AP-41-43 Washington Avenue

Examination of revised plans filed with application for permit for construction of a one story masonry building 30 feet by 42 feet at the above named location discloses the following details either to be missing or not in compliance with Building Code requirements.

Examination of plans filed with application for permit for construction of a one story masonry building 30 feet by 42 feet on the lot at the above named location discloses variances from and questions as to compliance with Zoning Ordinance and Building Code requirements as listed below. Before a permit can be issued it is necessary that revised plans indicating compliance be furnished for checking and approval. Details in question are as follows:

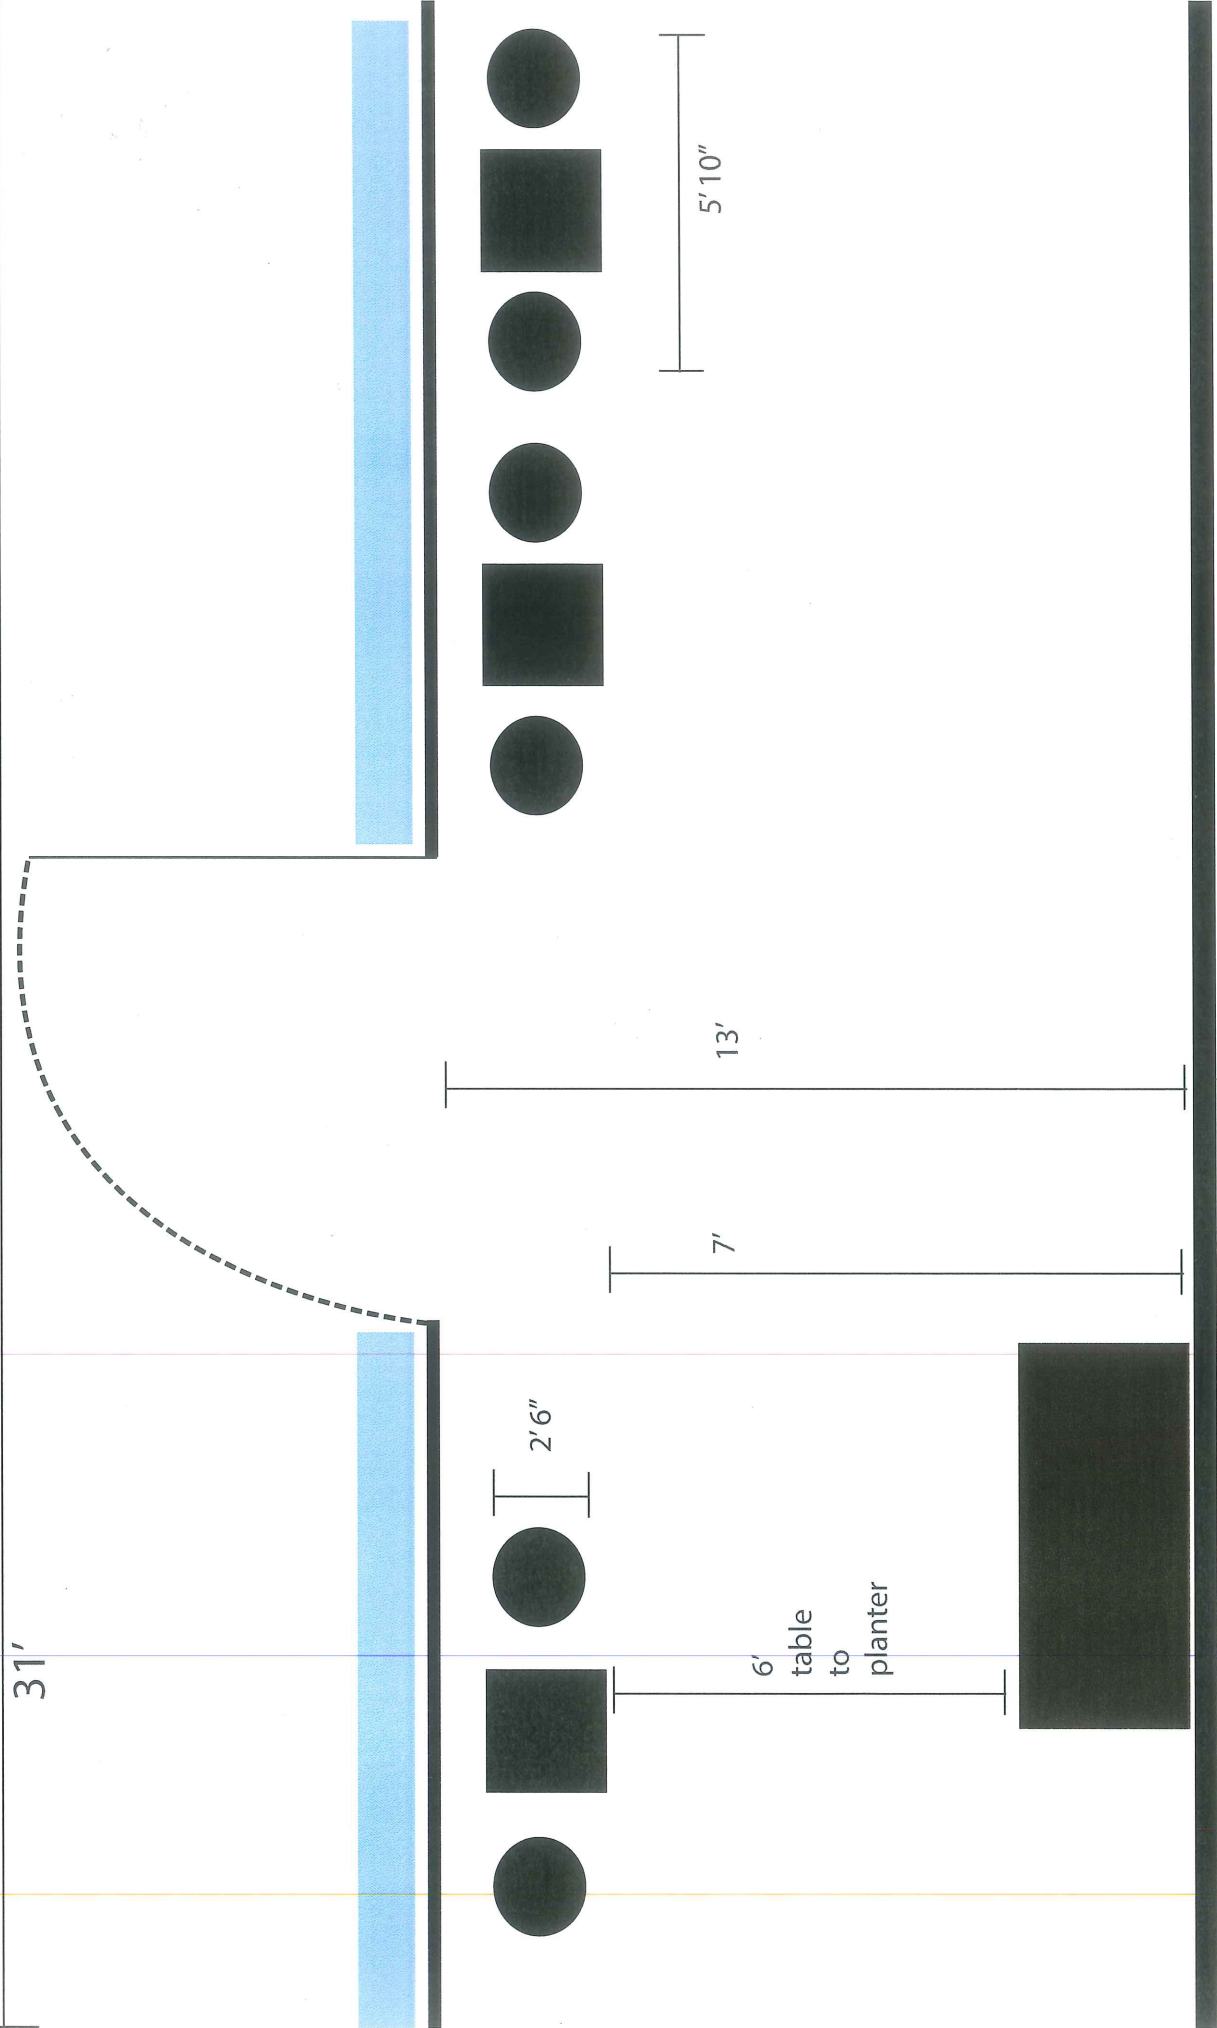
1. A revised plot plan is needed that will show building is to be located clear of right-of-way which crosses your property, that building is to be set back from street line far enough so that no part of any foundation wall footing will project into the bed of the street and that there is to be loading door provided in such a location that an off-street loading bay at least 14 feet wide by 45 feet long can be located all on private property outside of it.
